# KITTITAS COUNTY

### MEMORANDUM

DATE: October 24, 2011

SUBJECT: H&C Trust Short Plat SP-11-00011

| D. NELSON | 1"=200' | 1 OF 2 |

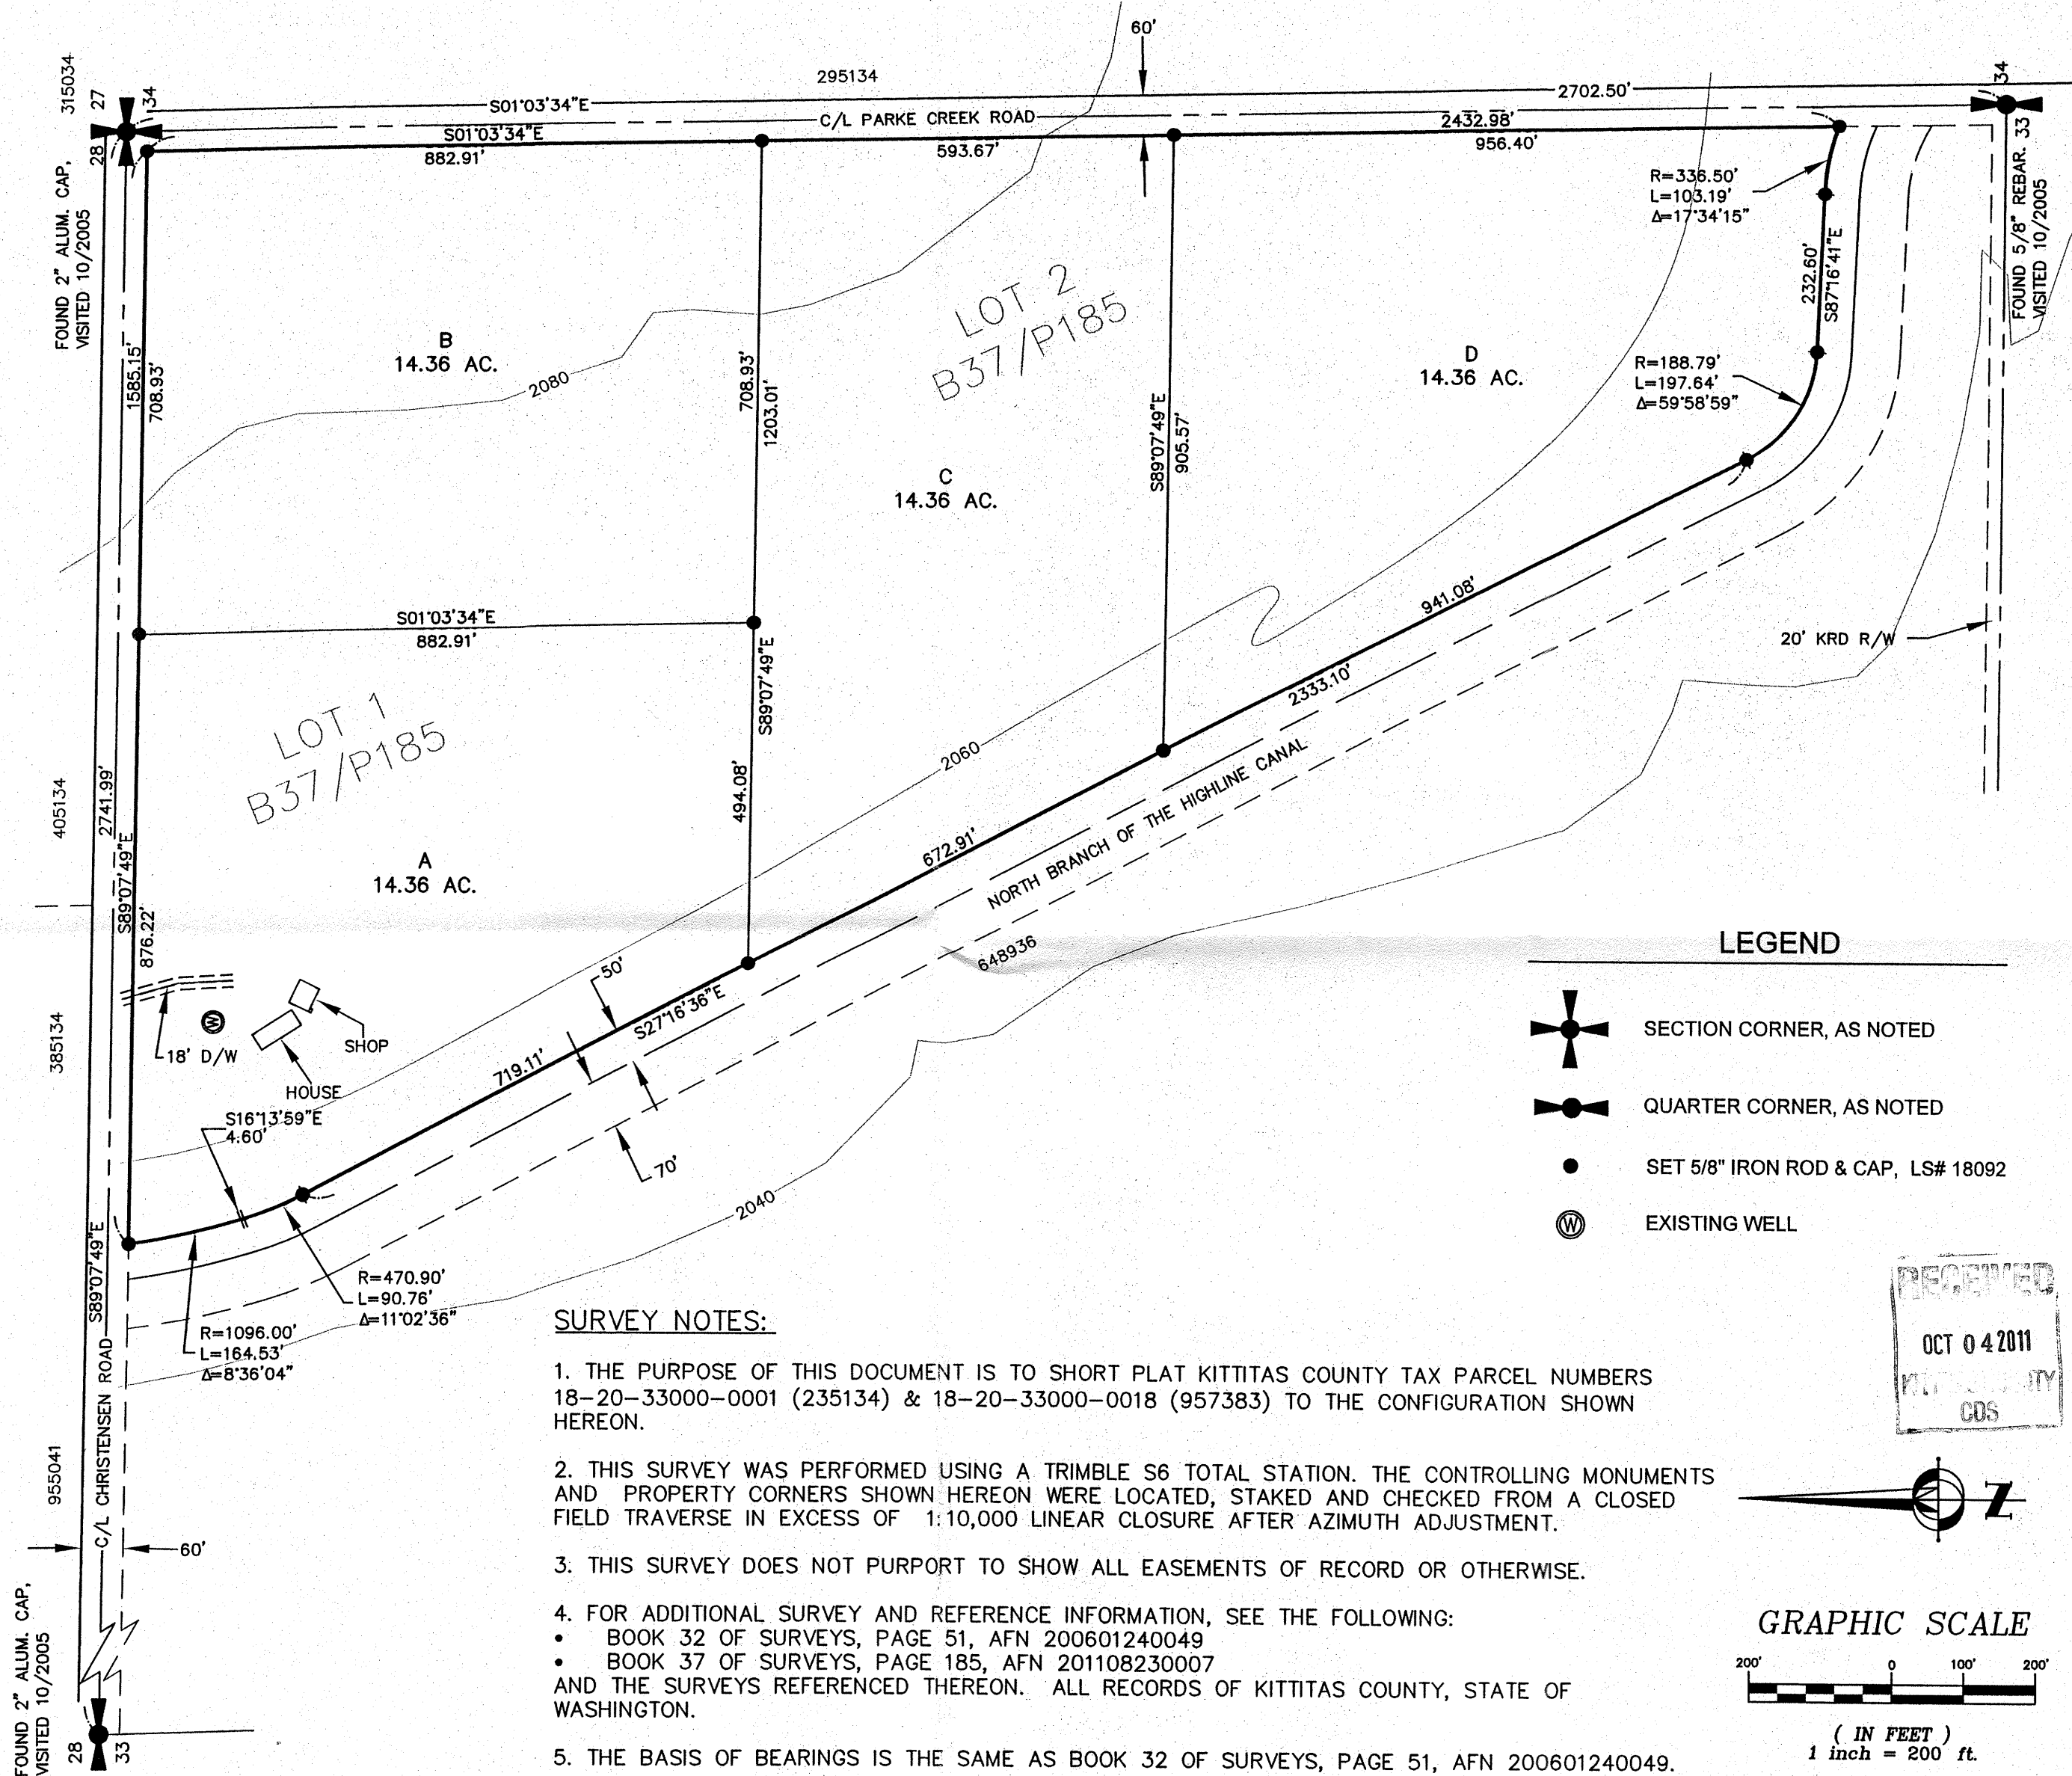
1. Joint-Use Driveway: A joint-use access shall serve no more than two tax parcels. See Kittitas County Road Standards, 9/6/05 edition.
  - a. Access easements shall be a minimum of 20' wide. The roadway width shall have a minimum width of 12'.
  - b. The surface requirement is for a minimum gravel surface depth of 6".
  - c. Maintenance of driveway approaches shall be the responsibility of the owner whose property they serve. The County will not maintain accesses.
  - d. Any further subdivision or lots to be served by proposed access may result in further access requirements.

Single-Use Driveway: A single-use access shall serve no more than one lot. See Kittitas County Road Standards, 9/6/05 edition.

- a. The roadway shall be a minimum of 8' wide with gravel surface.
  - b. Maintenance of driveway approaches shall be the responsibility of the owner whose property they serve. The County will not maintain accesses.
  - c. Any further subdivision or lots to be served by proposed access may result in further access requirements.
